North Littlehampton, Fitzalan Link S278 Works

Stage 1 RSA – Road Safety Audit Addendum Response Report

1.1 This report results from receipt of a Stage 1 RSA Addendum Report, undertaken dated August 2017.

rev.
P5

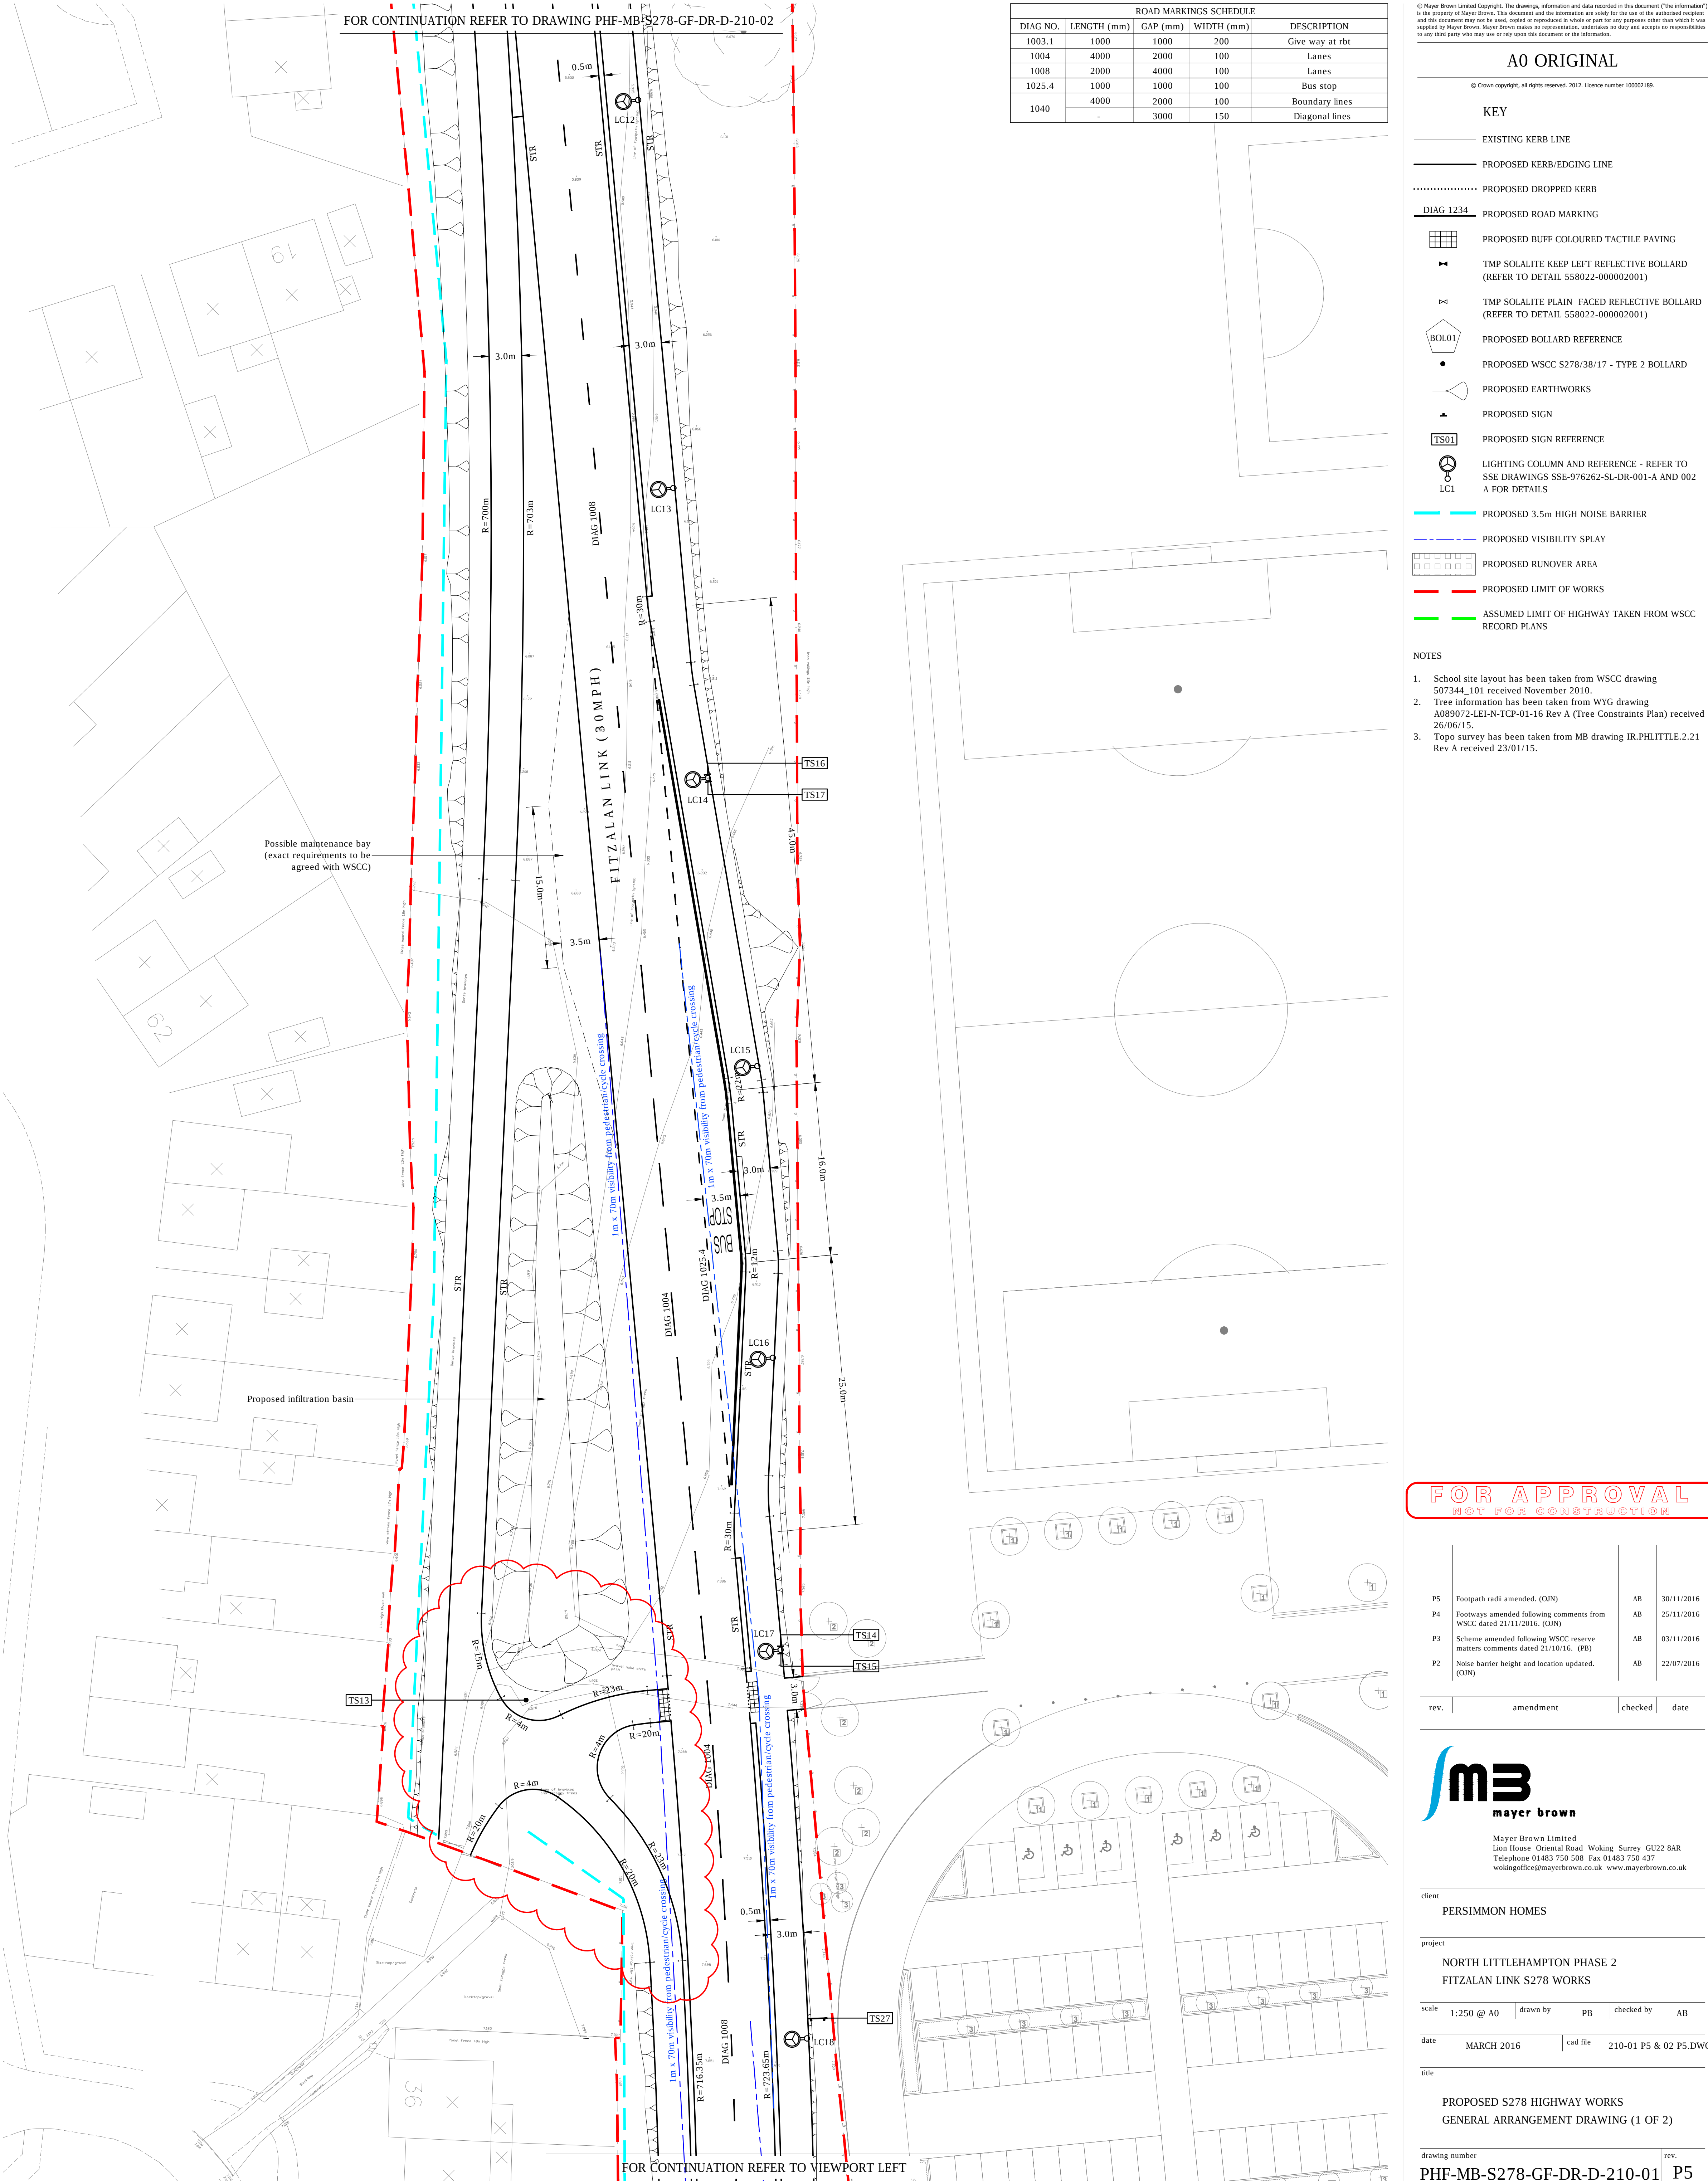
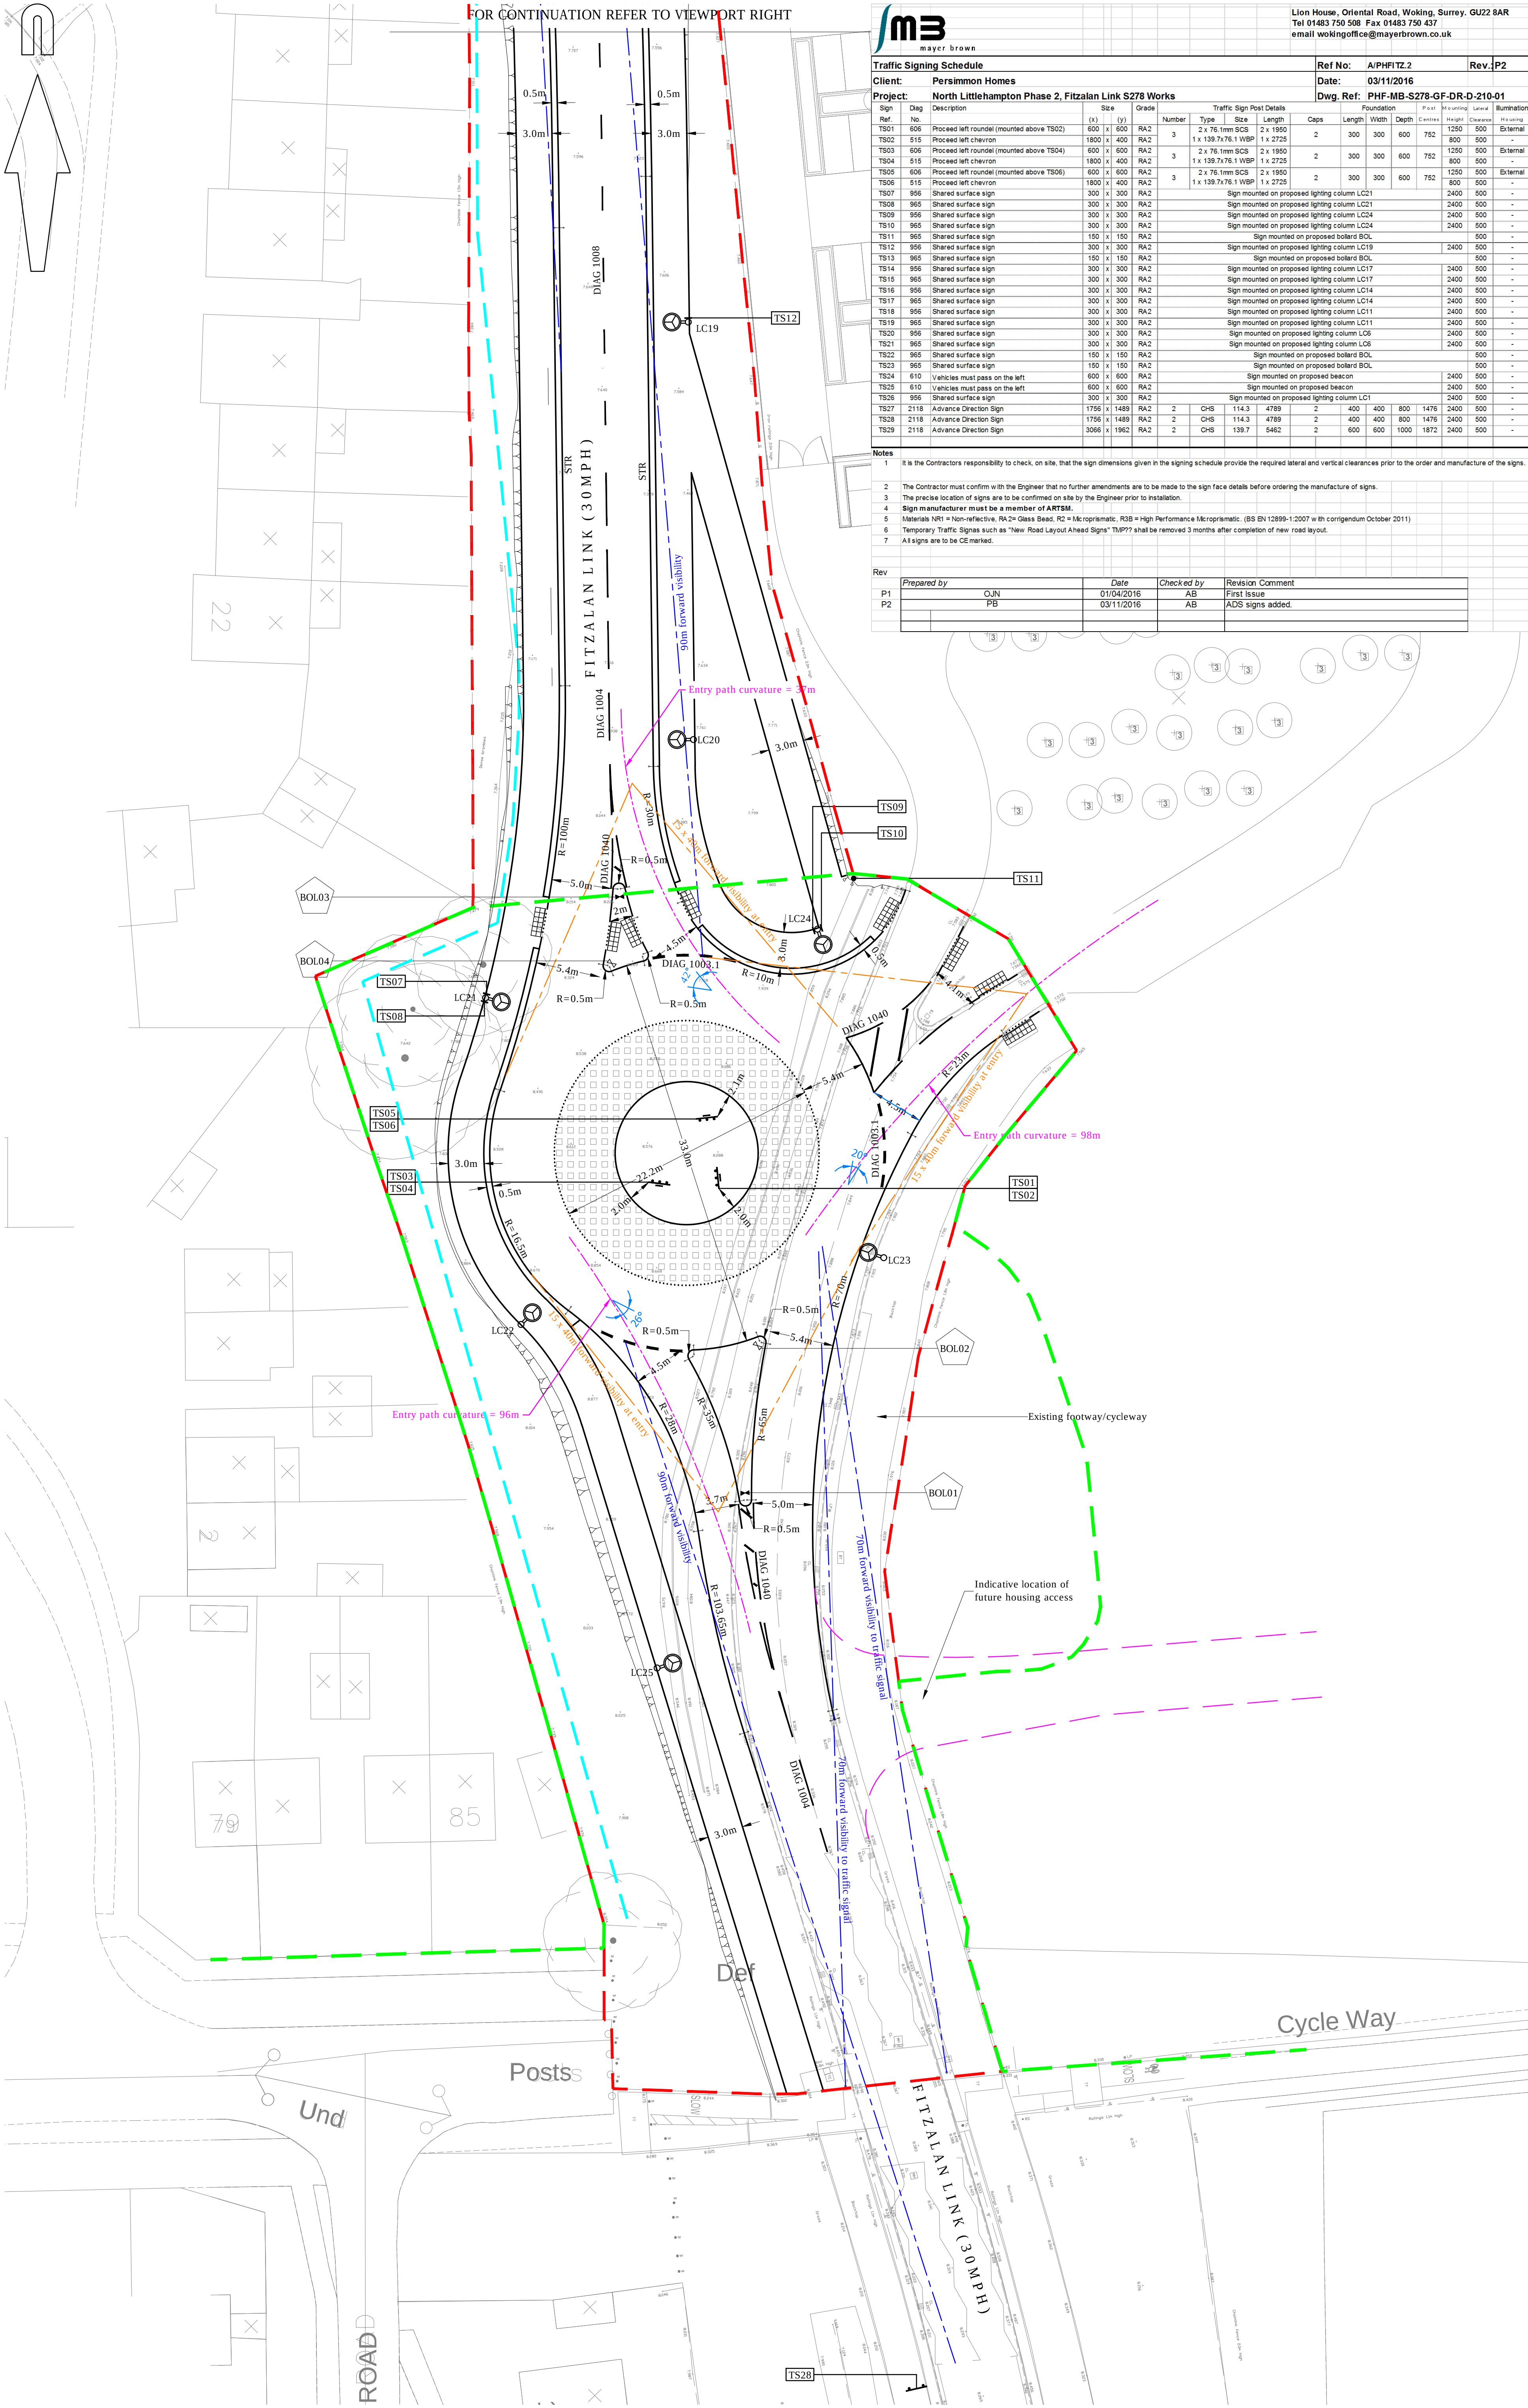
2.5	Location: Fitzalan Link Road (please refer to reference point 2.5 in Appendix B) Summary: Incorrect roundels provided on traffic island The traffic bollards to be provided on the proposed traffic island will have plain face roundels, indicating that vehicles can pass either side of the island. This could result in vehicles passing the island on the offside resulting in a head on type collision with an oncoming vehicle.	Ensure 'keep left' roundels are provided on the proposed traffic bollards.	Partially accepted. The bollard on the southern side of the pedestrian island has been replaced with a keep left bollard as recommended. However, due to the right turn lane to the north of the traffic island the north bollard needs to remain plain faced.
